Addendum No. 1

RE: Contract # C204553

Pender County (R-3300B)

NC-417 (HAMPSTEAD BYPASS) FROM SOUTH OF NC-210 TO NORTH OF SR-1563 (SLOOP POINT LOOP RD)

PROJECT REFERENCE NO.	SHEET NO.
R-3300B	RW33
Location and Surveys	
<small>801 JONES FRANKLIN ROAD RALEIGH, NC 27605 LICENSE NO. 55827 WWW.STANTEC.COM</small>	
DOCUMENT NOT CONSIDERED FINAL UNLESS ALL SIGNATURES COMPLETED

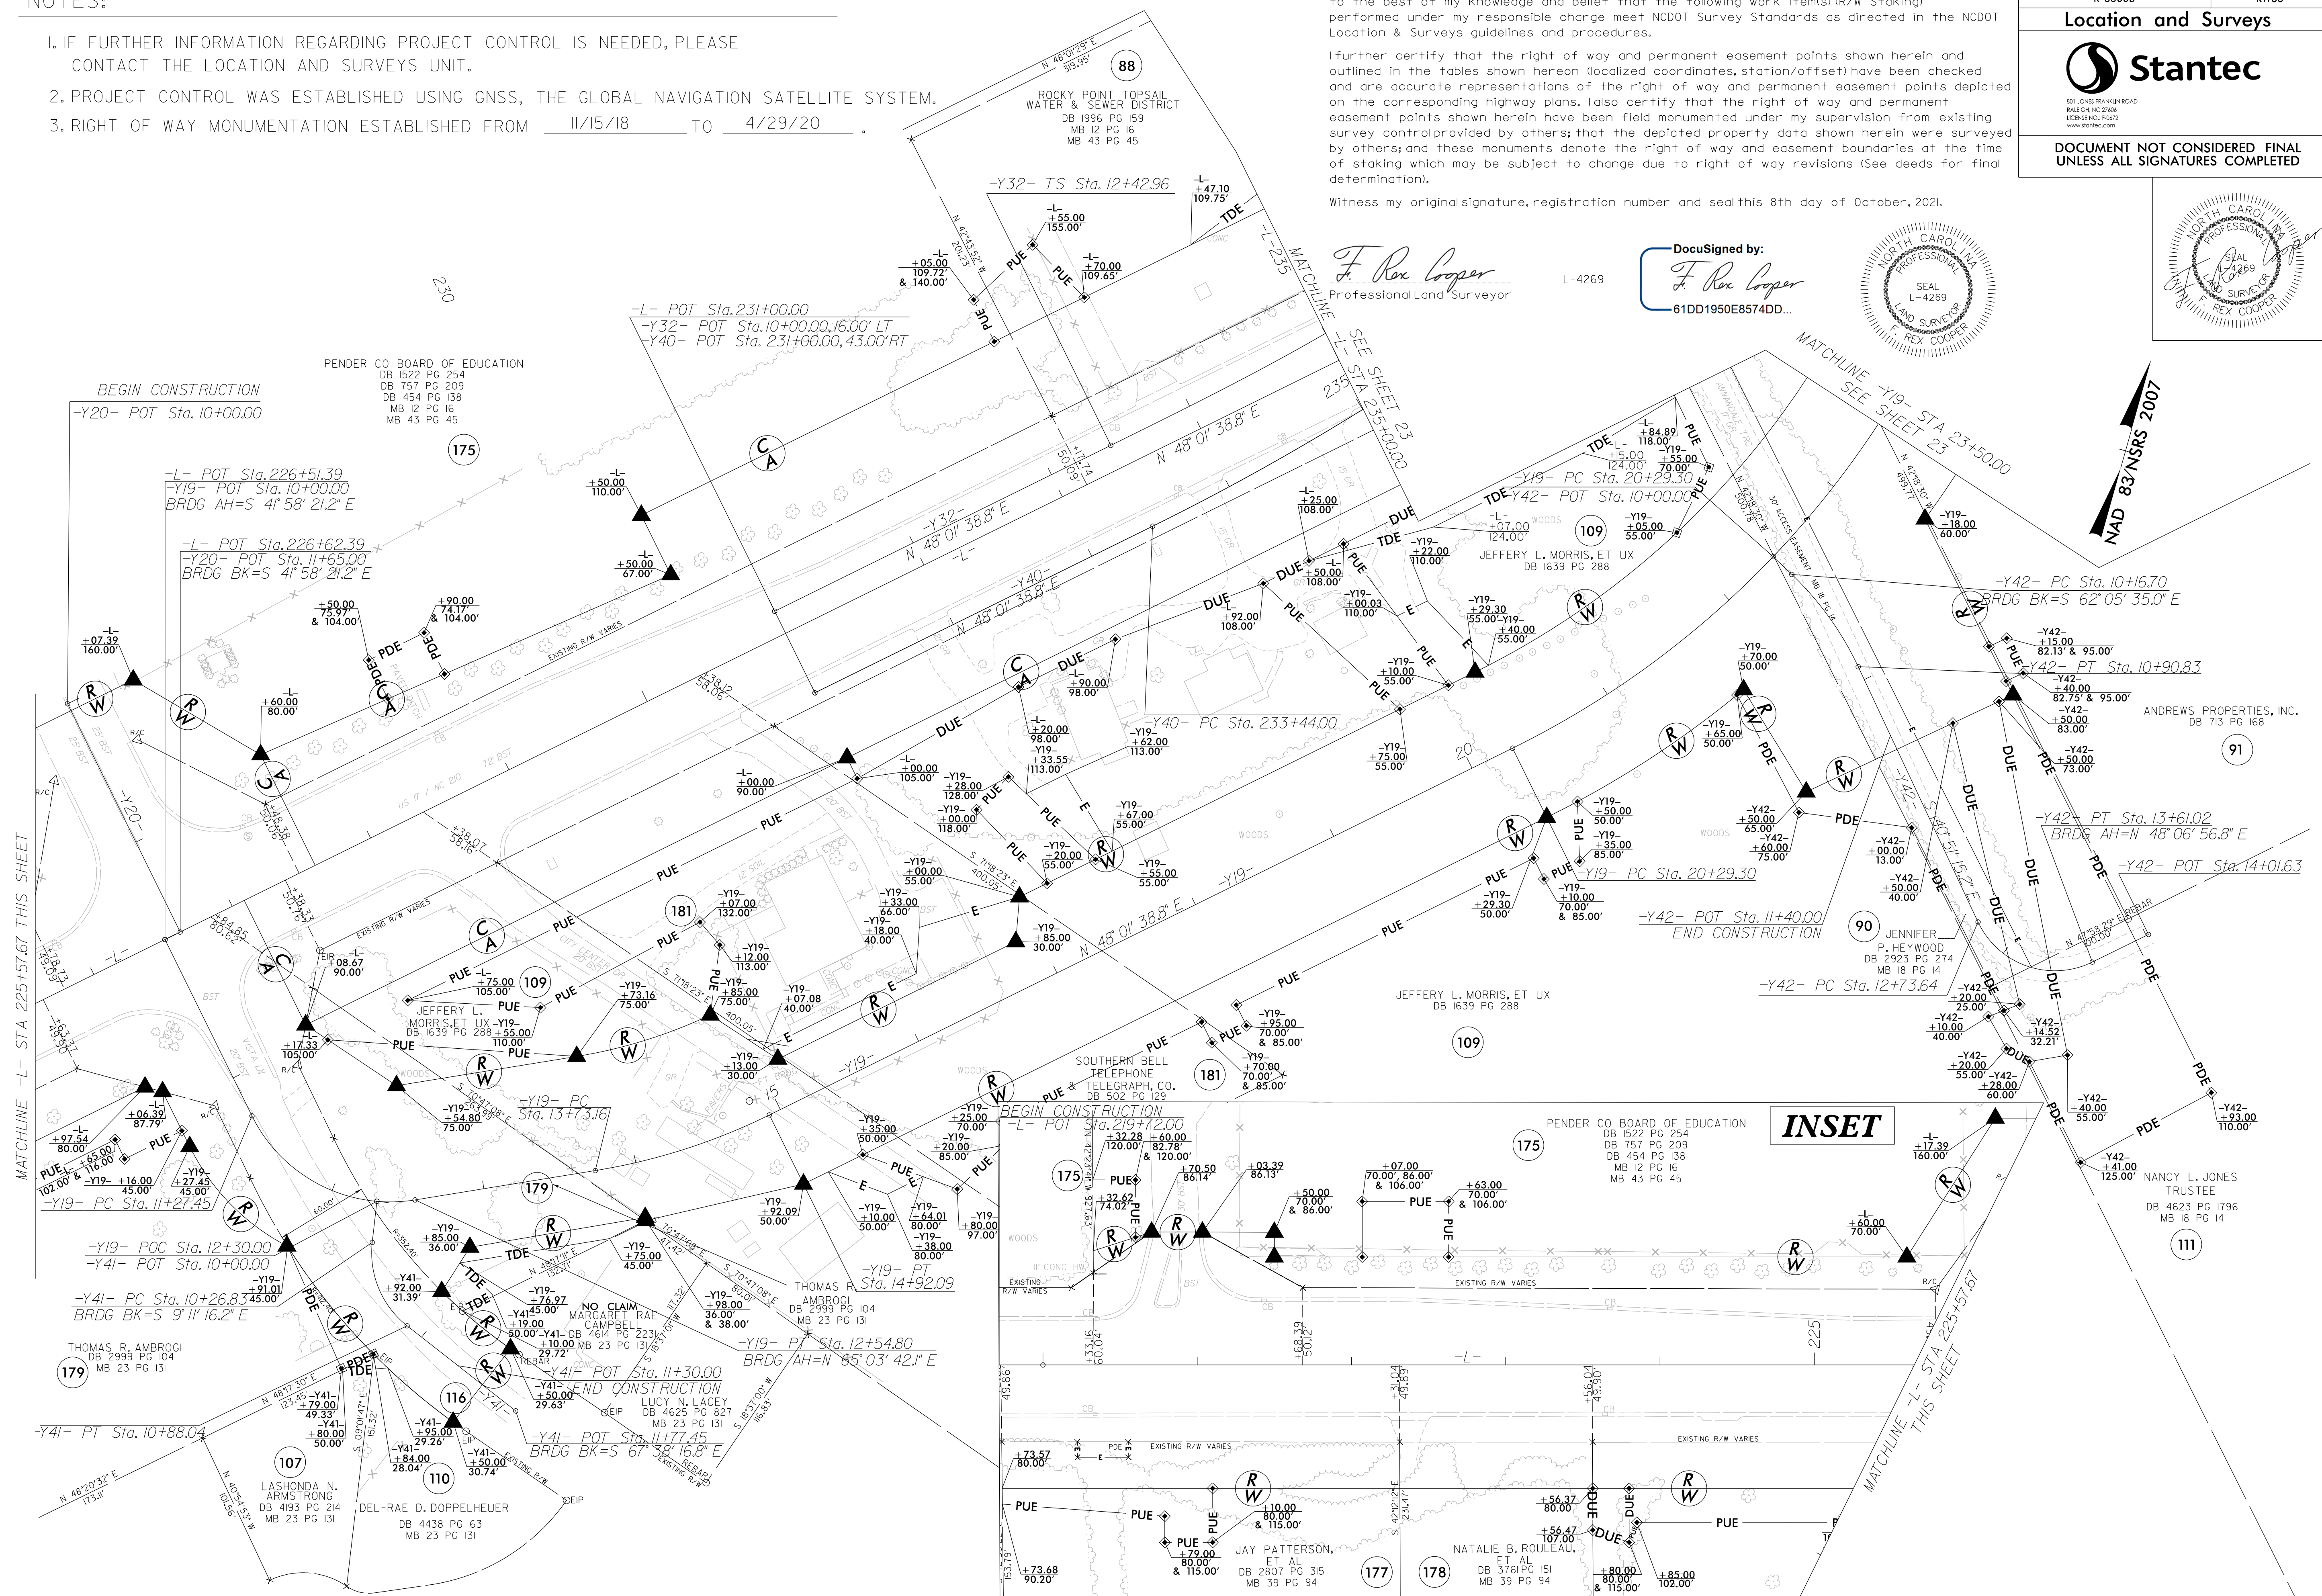
Sheet No.	Revision
23	Right of Way information modified.
33	Right of Way information modified.
